Application Ref:	3/2026/0446			 Ribble Valley Borough Council www.ribblevalley.gov.uk
Date Inspected:	31/07/26	Site Notice:	31/07/26	
Officer:	LW			
DELEGATED ITEM FILE REPORT:				APPROVAL

Development Description:	Proposed erection of 9no. holiday lodges.
Site Address/Location:	Ribble Valley View, Old Langho Road, Langho, BB6 8AW.

Public Footpath
FP0306005 Diversion

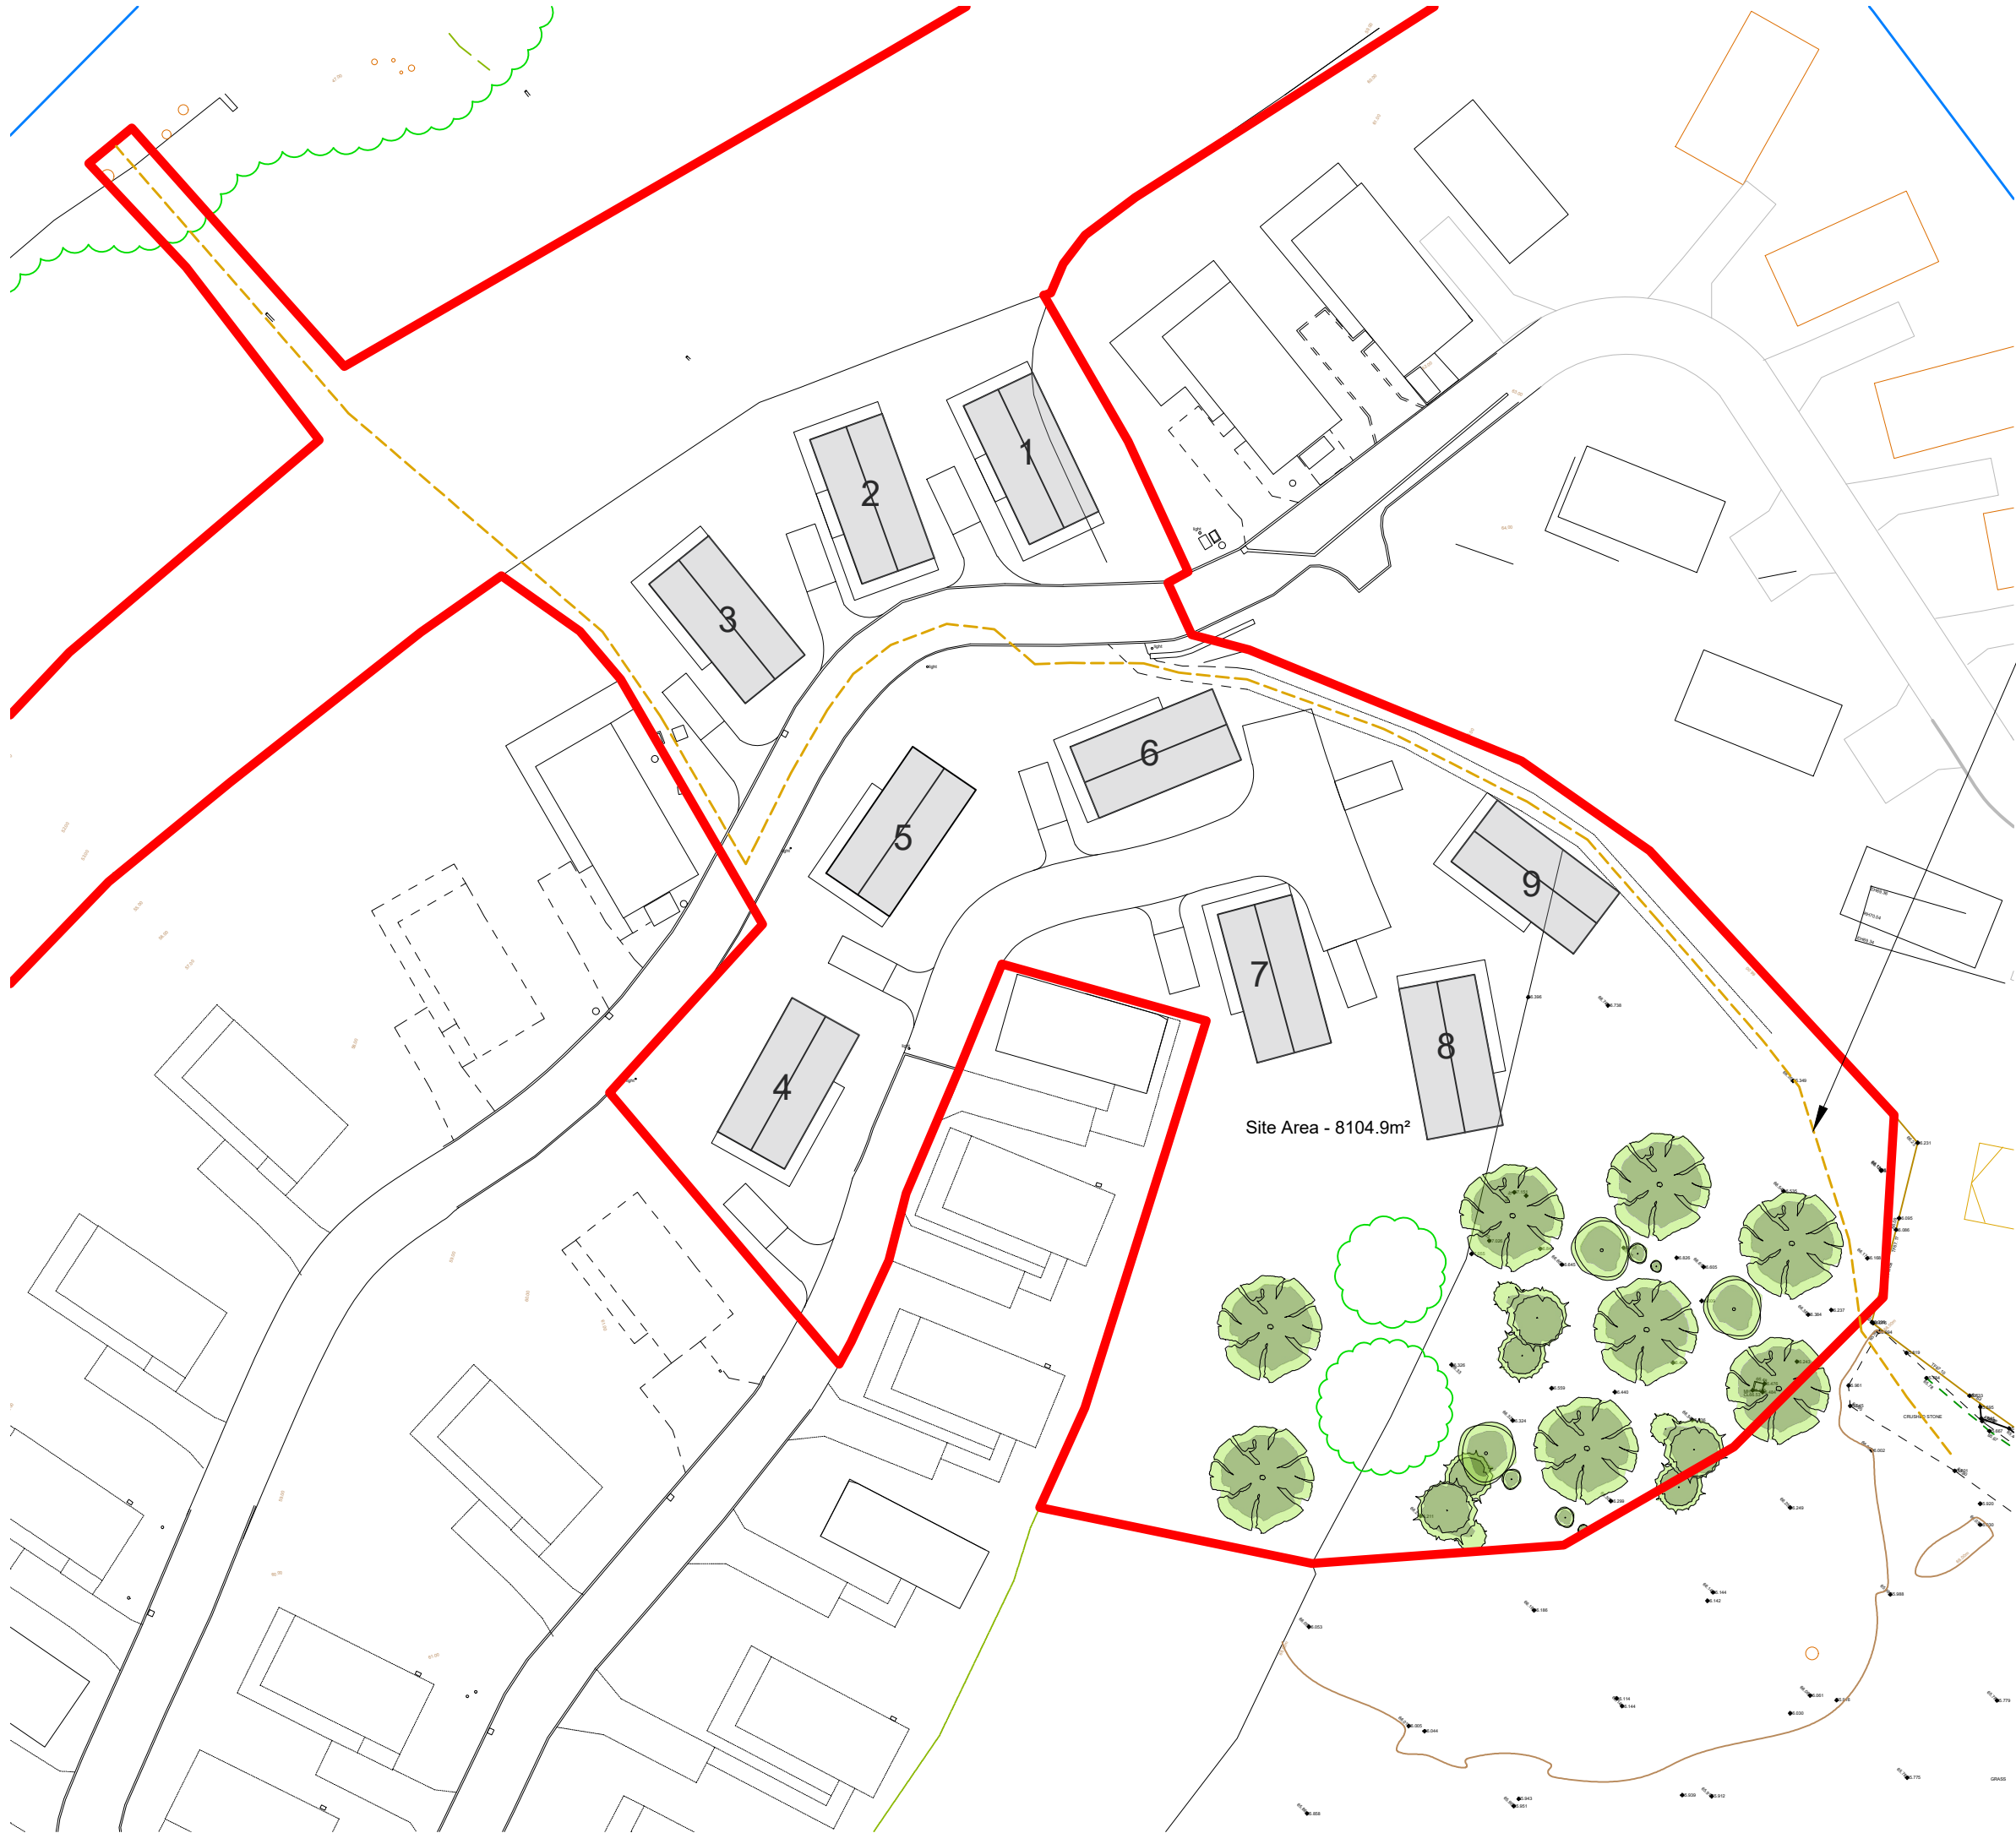
The LHA noted that Plots 1-3 would be positioned adjacent to the existing internal road, while a new internal road is proposed to provide access to Plots 4-9. The width of the proposed internal road network would be comparable to that of the existing on-site layout, and a turning head is proposed at the end of the access road to facilitate vehicle manoeuvring.

The submitted plans indicated that a minimum of one parking space would be provided for each holiday lodge. However, the LHA advised that, as the lodges would comprise either two or three bedrooms, a minimum of two parking spaces should be provided per unit.

Following this an amended Proposed Site Plan was submitted by the applicant. This has been reviewed by the LHA, and no objections have been raised. The Plan shows that a minimum of two car parking spaces would be provided for each holiday lodge, which is considered acceptable.
